CITY OF PORTLAND, MAINE

AUGUST 29, 2011

Project Name:	ENTERPRISES RENT-A-CAR	Project ID:	2011-246
Address:	1128 WESTBROOK STREET	CBL:	INSERT CBL
Applicant:	ENTERPRISE HOLDING, LLC		
Planner:	SHUKRIA WIAR

ENTERPRISES RENT-A-CAR
1128 WESTBROOK STREET
LEVEL III SITE PLAN
PROJECT ID# 2011-246
ENTERPRISES HOLDING, LLC, APPLICANT

COBB AVENUE

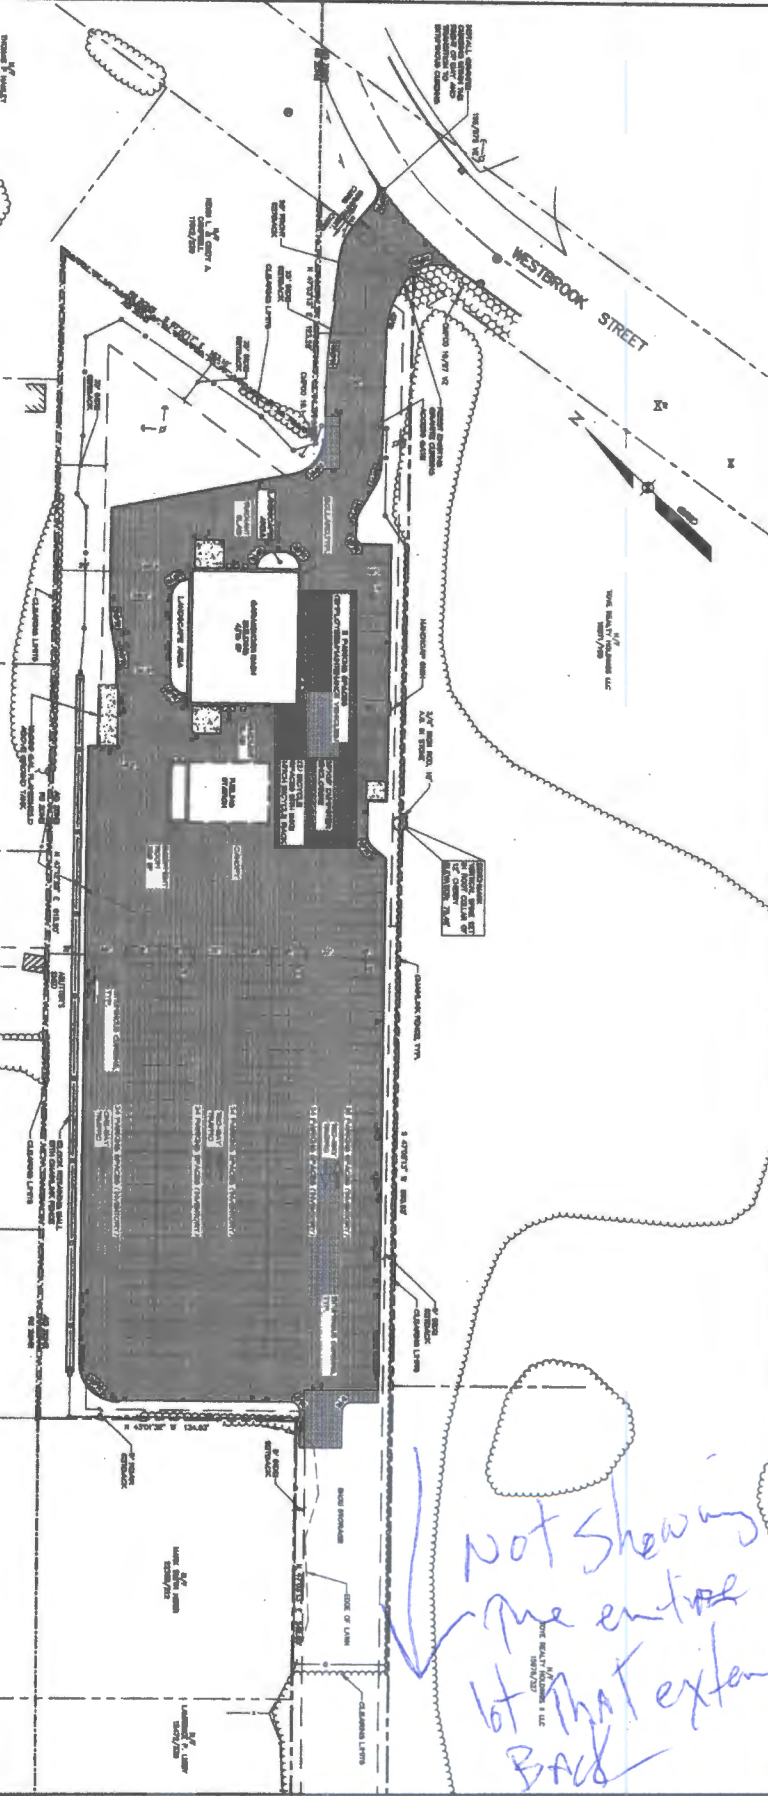
2. The applicant shall submit a revised site plan that shows the narrowing of the driveway width for review and approval by the Planning Authority and the Traffic Engineer.

Tom Errico, Consultant Traffic Engineer, recommends that the driveway width be reduced from 30 feet to 24 feet as it enters the site. If such a revision was made to the proposal, it would reduce the paved area on the site by 500 square feet. The applicant has agreed to reduce the driveway width to twenty-four (24') feet for a portion of its length; the total length of the driveway is approximately a hundred and fifty (150') feet. The driveway curb cut ranges from 38 to 30 feet, which is designed to accommodate the turning movements of the vehicle delivery trucks. The applicant provided the turning templates to substantiate the need for the wide curb cut. Mr. Errico supports the waiver based upon the truck turning template information and the skewed alignment of the proposed driveway (Attachment 2). A waiver of the 30 foot driveway entrance is proposed for the Board's consideration and the following condition is proposed for the reduction in driveway width.

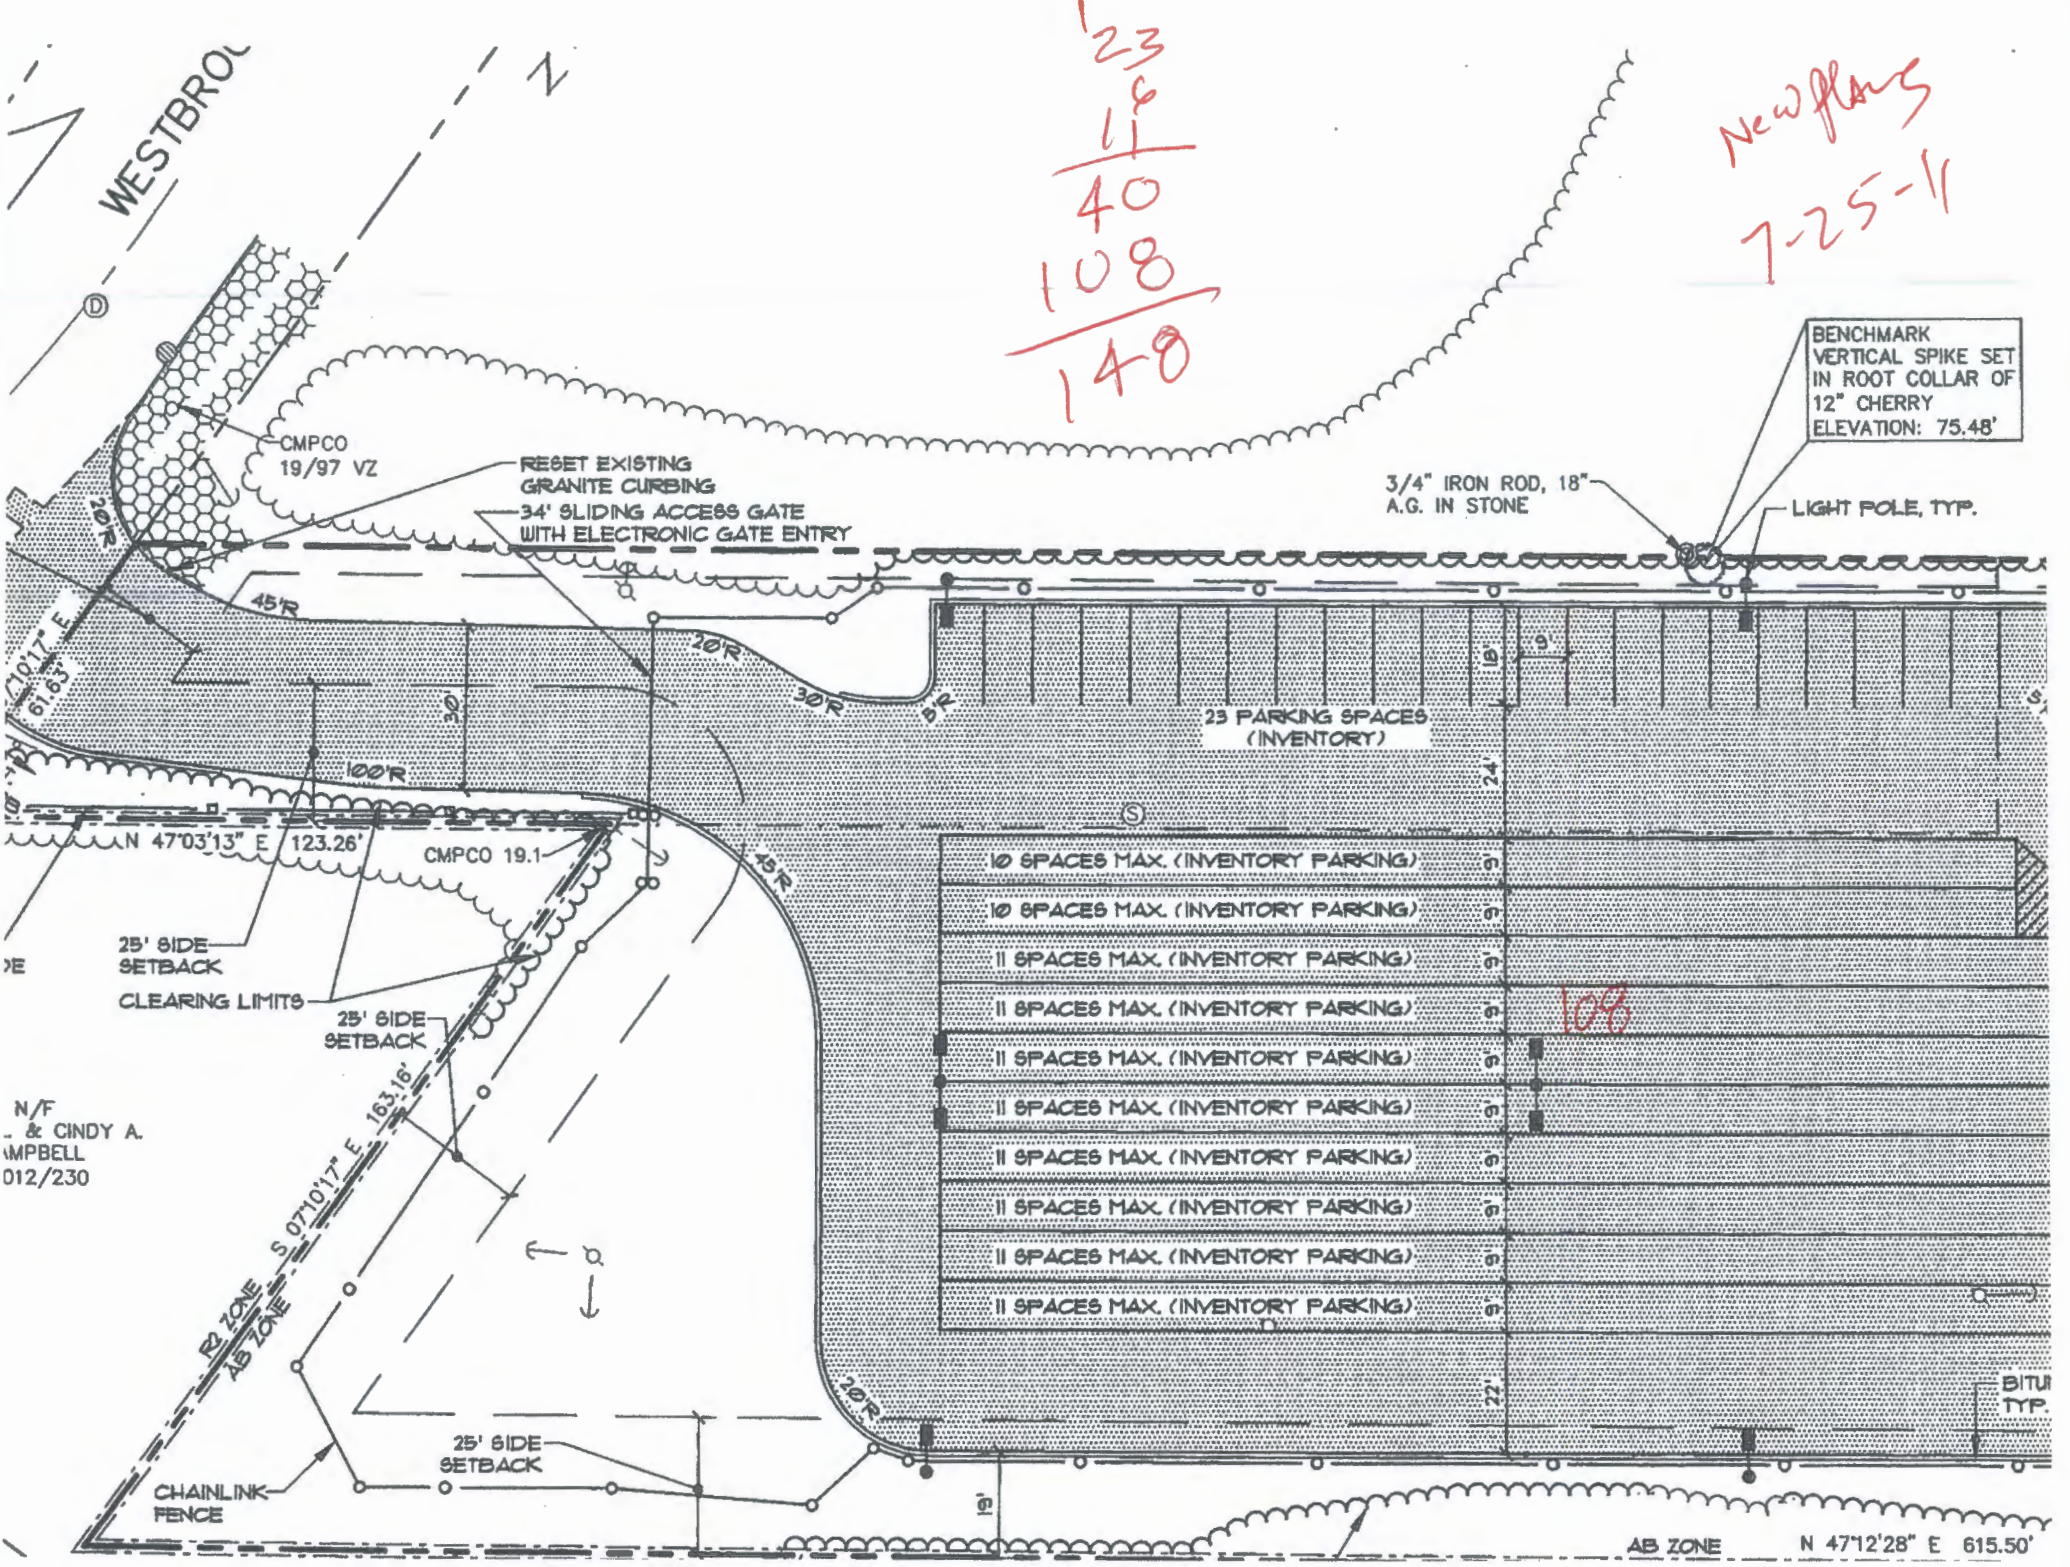
Final location of planted landscaping shall be coordinated with the City Arborist. All attempts shall be made to protect existing mature trees and vegetation and new plantings will complement preserved native plants. Prior to construction activity for preparing the site for base grading, the contractor and the owner, or owner's representative shall review with the City's Arborist existing tree planting to be considered for saving, and mark such trees for protection. Prior to final planting, the contractor or parties responsible for landscaping shall adjust proposed planting locations with the City Arborist to maximize buffering affects.

At the pre-construction meeting, the City Arborist shall inspect proposed buffers and landscaping for potential tree save, limits of clearing and proper preservation of vegetation with measures of protection in place. City Arborist shall be notified prior to any cutting. During construction, the site shall be reviewed by the City Arborist for the final planting of proposed trees and landscaping in a manner to benefit the neighbors for present and future visual screening.
